# CITY OF ALBUQUERQUE

**RE: Cibola Loop Multifamily  
Conceptual Grading Plan  
Engineer's Stamp Date: 11/06/2024  
Hydrology File: A13D011B**

**RE: Cibola Loop Multifamily  
Conceptual Grading Plan  
Engineer's Stamp Date: No Stamp Date  
Hydrology File: A13D011B**

Based upon the information provided in your submittal received 07/31/2024, the Conceptual Grading Plan **is not** approved for action by the Development Facilitation Team (DFT) on Site Plan for Building Permit. The following comments need to be addressed for approval of the above referenced project:

RONALD R. BOHANNAN P.E. #7868	CIBOLA LOOP APARTMENTS ALBUQUERQUE, NM	DRAWN BY LN
	CONCEPTUAL GRADING & DRAINAGE PLAN	DATE 07/16/2024
	 5571 MIDWAY PARK PLACE NE ALBUQUERQUE, NM 87109 (505) 858-3100 www.tierrawestllc.com	2024040_BASINS
		SHEET # GR-1
		JOB # 2024040

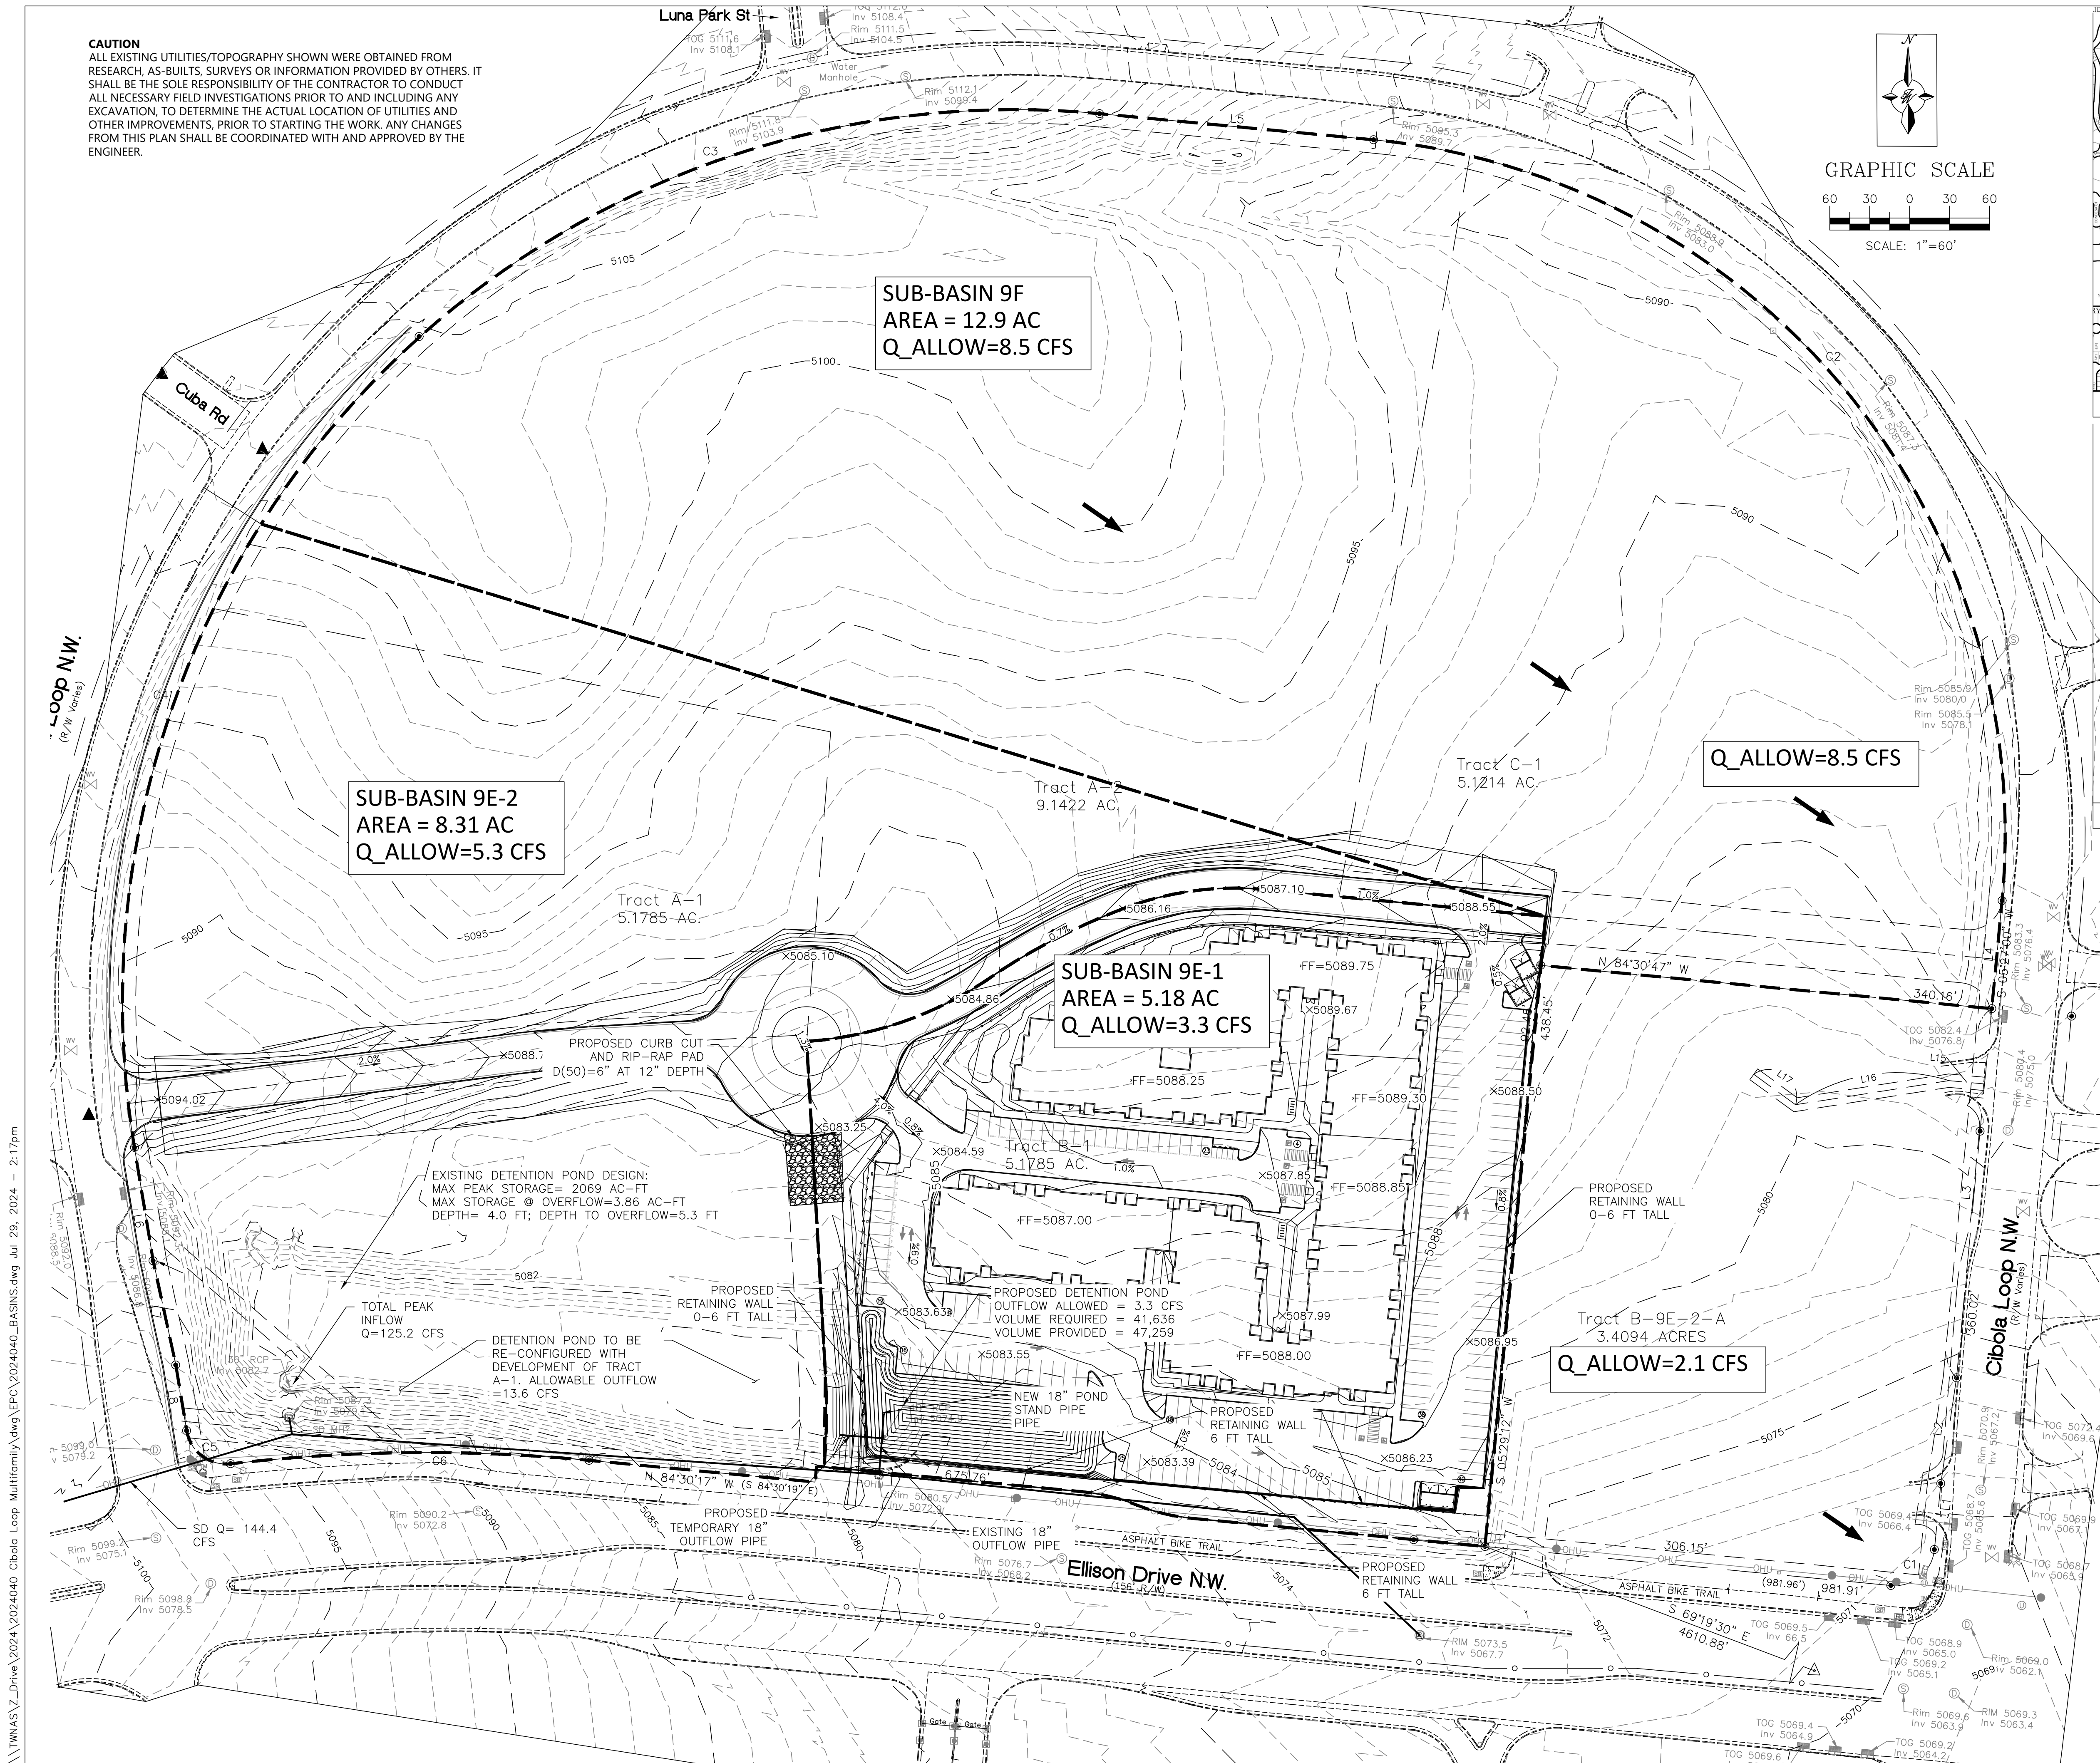
1. Please show the existing CoA Police Station that is on Tract B-9E-2-A which has been there since 2011. I do not think that the shown contours are current and reflect the benchmark change. This should be updated.

3. Please provide the Benchmark information (location, description and elevation) for the survey contour information provided.

4. Please provide the legal description of the property.

**RESPONSE:** It was determined that the previous contours were not current, a new topo survey was provided by a registered surveyor on 10/04/2024 that shows current contours around the perimeter of the police station.

**RESPONSE:** Benchmark information provided on sheet GR-1 NAVD 88 ACS Monument "6\_A13"

**RESPONSE:** Legal description added to sheet GR-1.

Cibola Loop NW

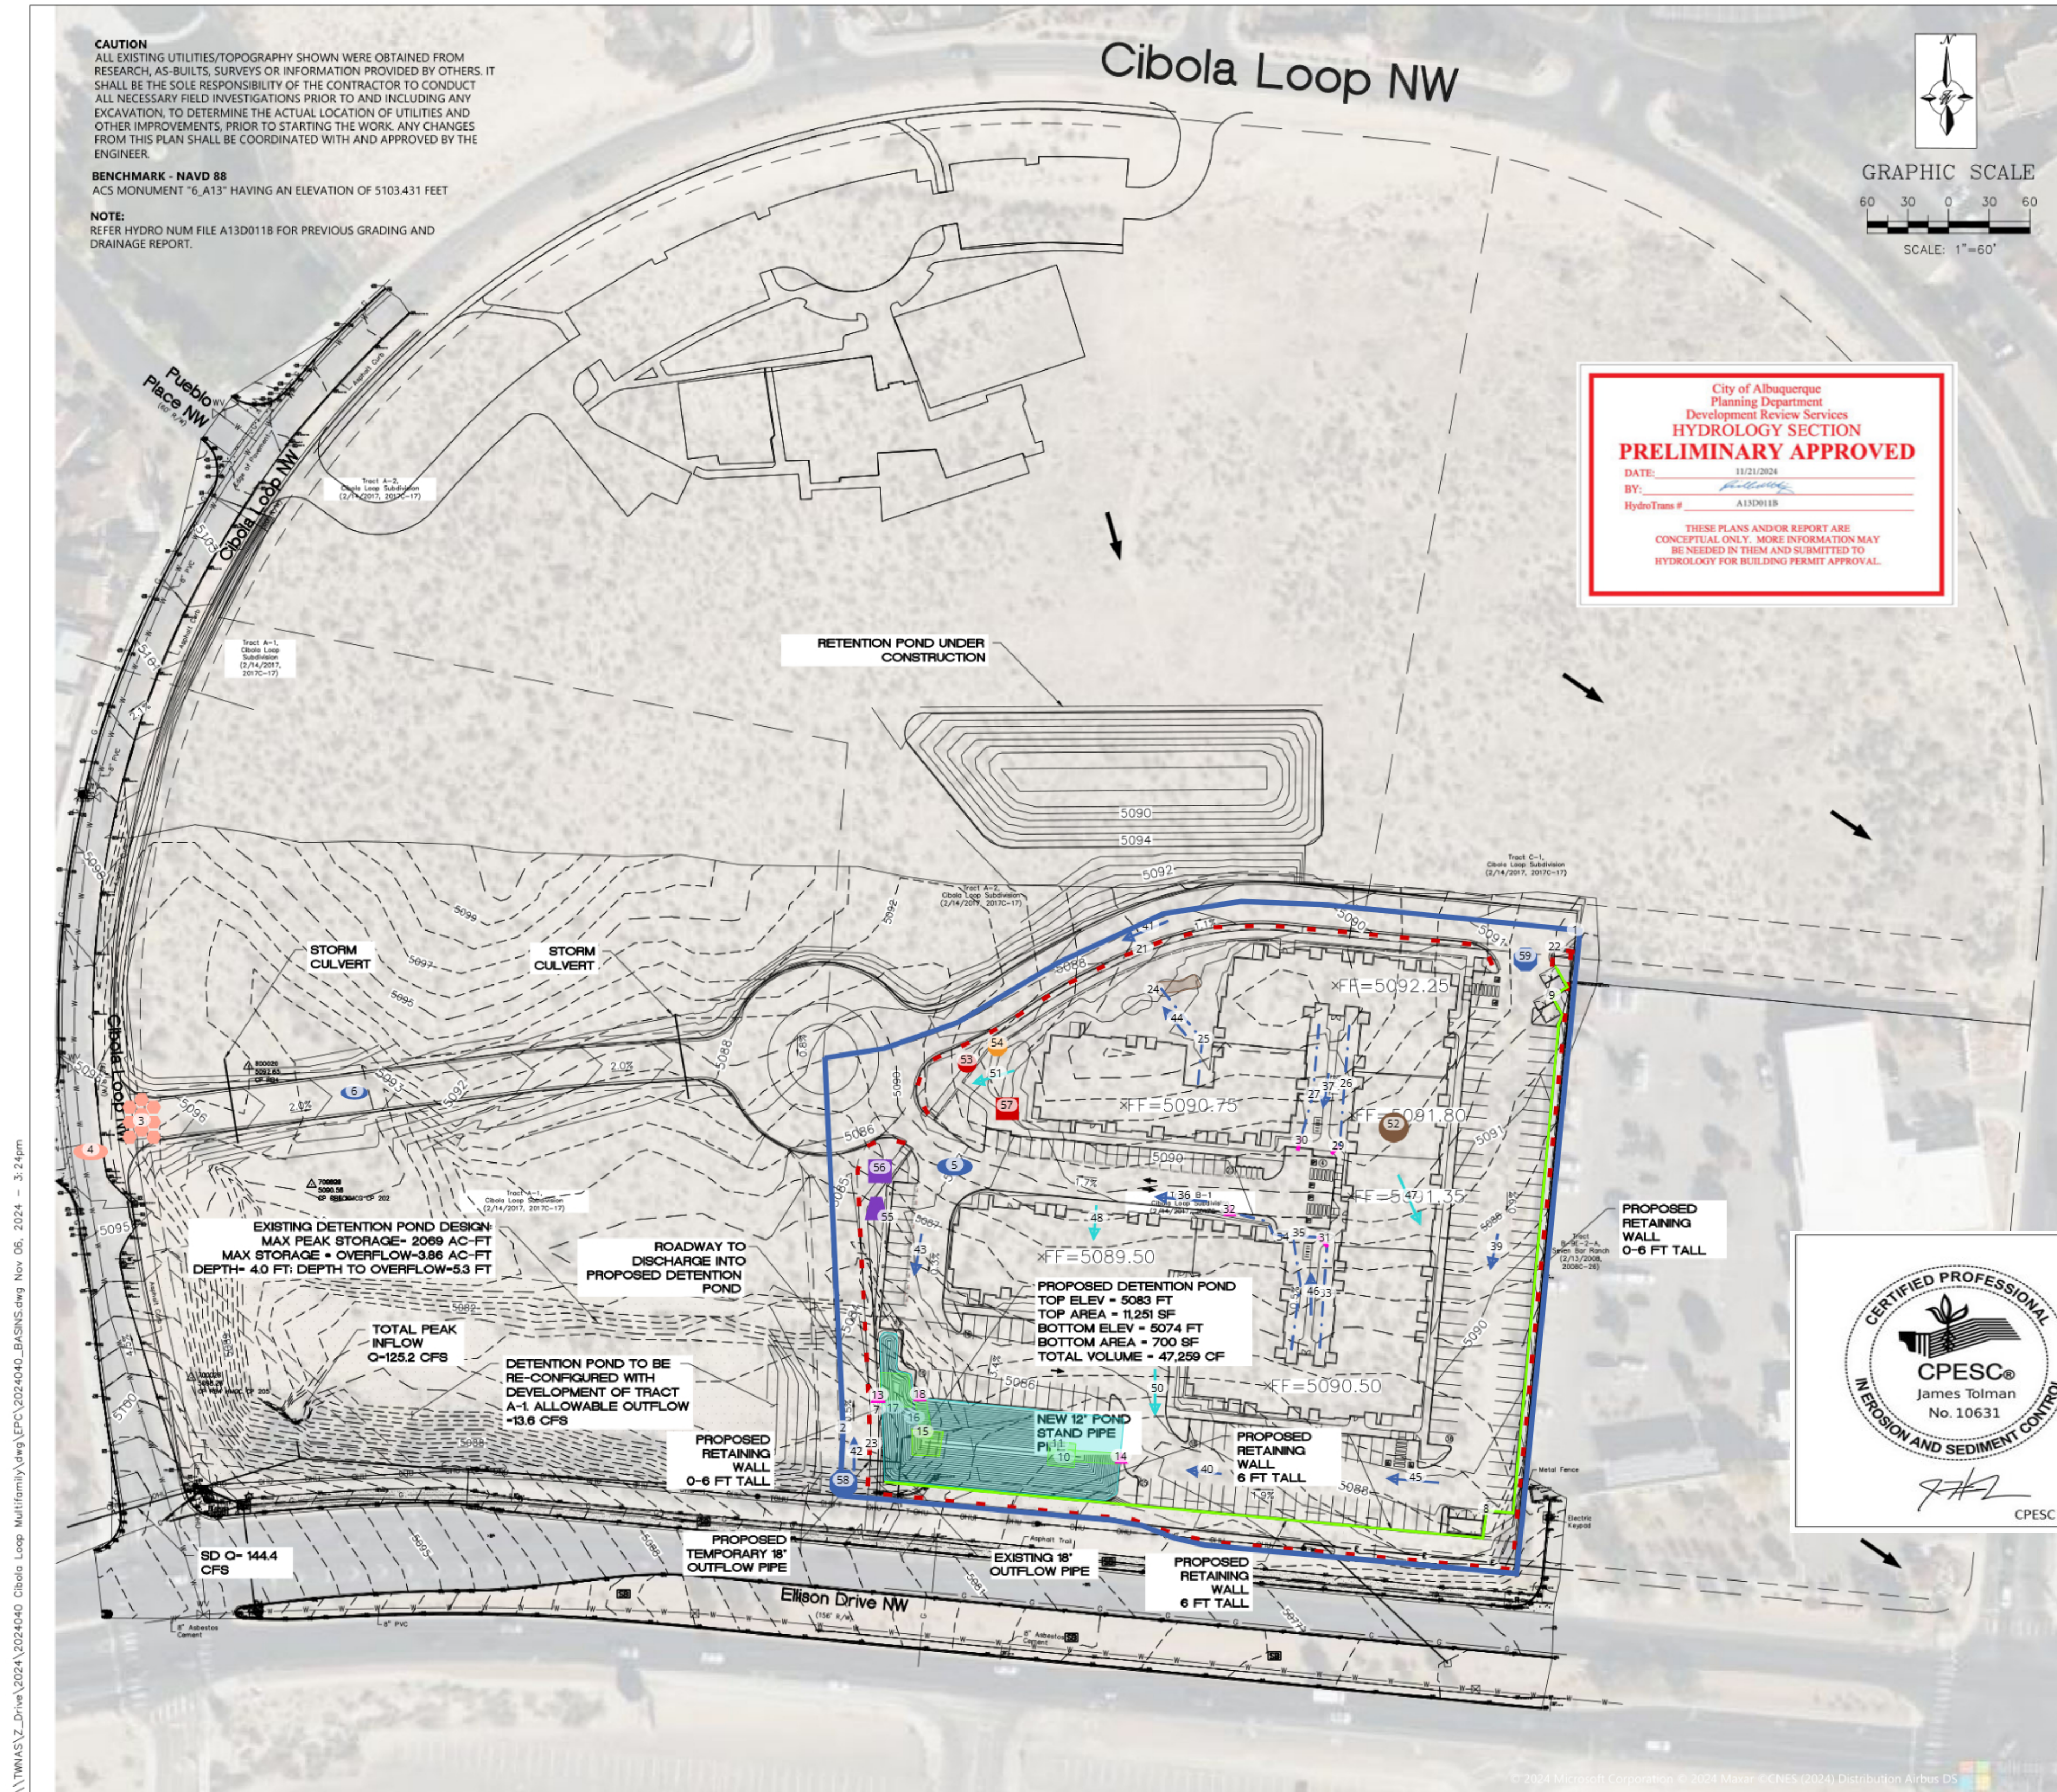
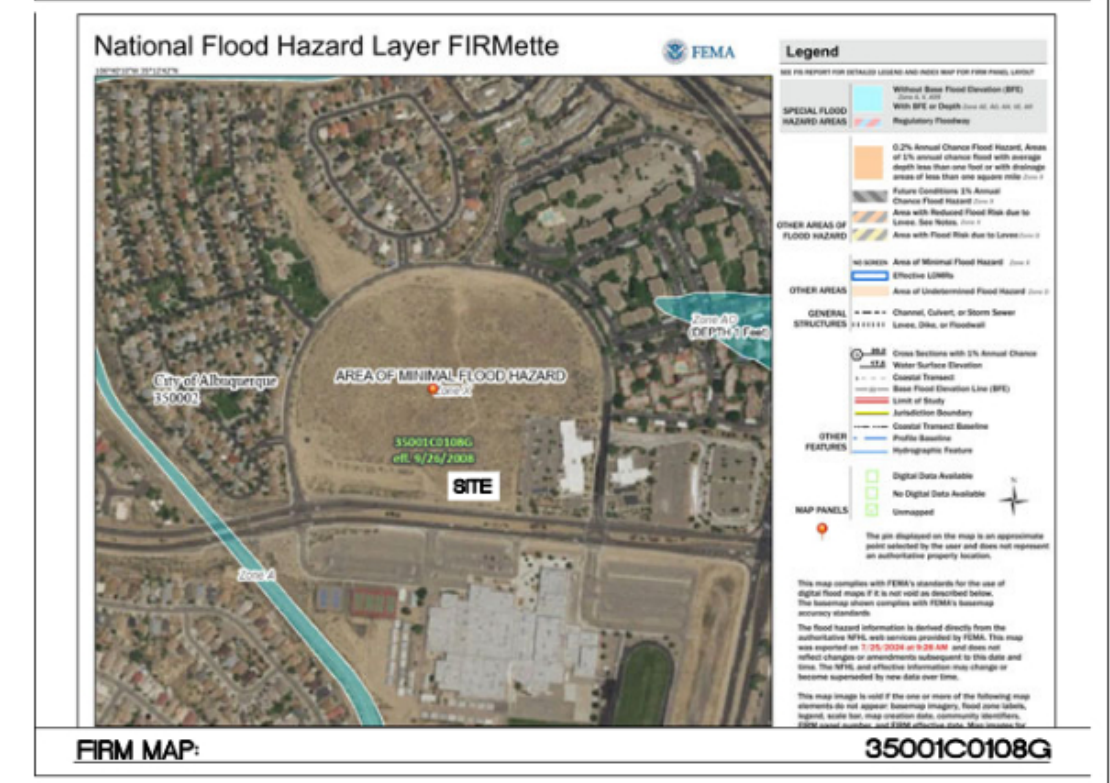
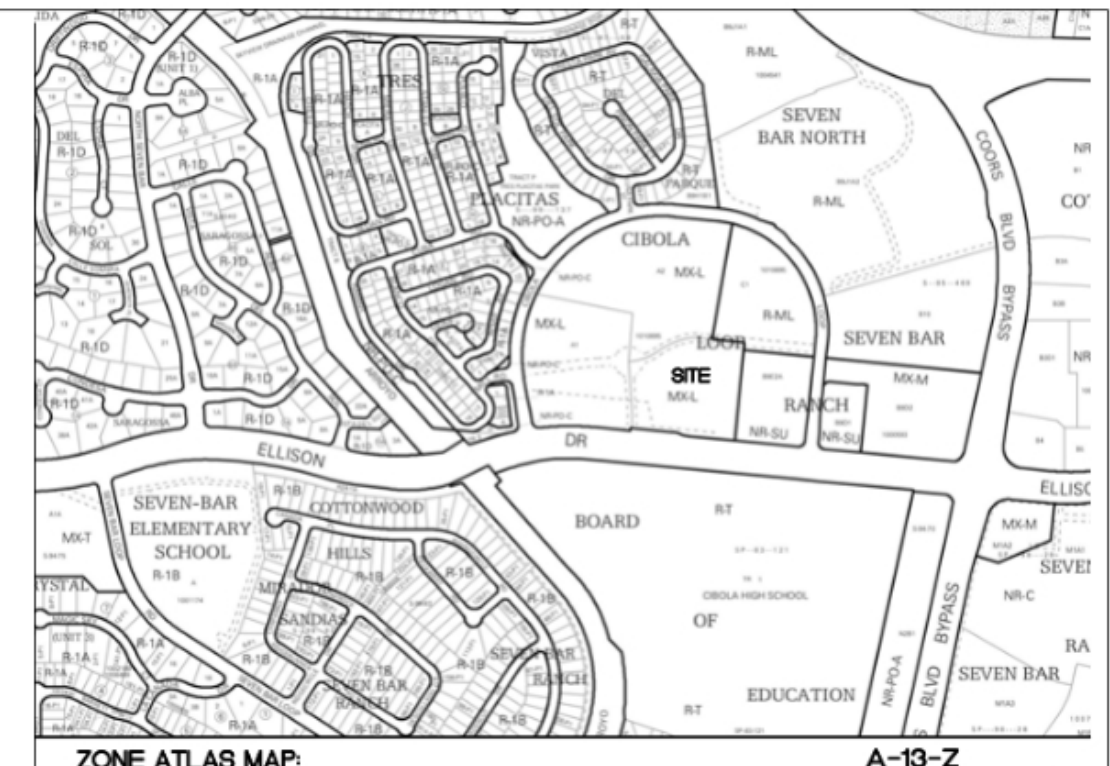
8. Please provide a section of the proposed detention pond showing the top of bank and the bottom of bank. Also, please show the location of the maintenance ramp.

10. Please provide the calculation for the required Stormwater Quality Pond per the DPM Article 6-12. To calculate the required SWQV, multiply the impervious area draining to the BMP by 0.42 inches for new development sites.

**RESPONSE:** See cross section A on sheet GR-3.

**RESPONSE:** See sheet GR-3 storm water quality calculations table.
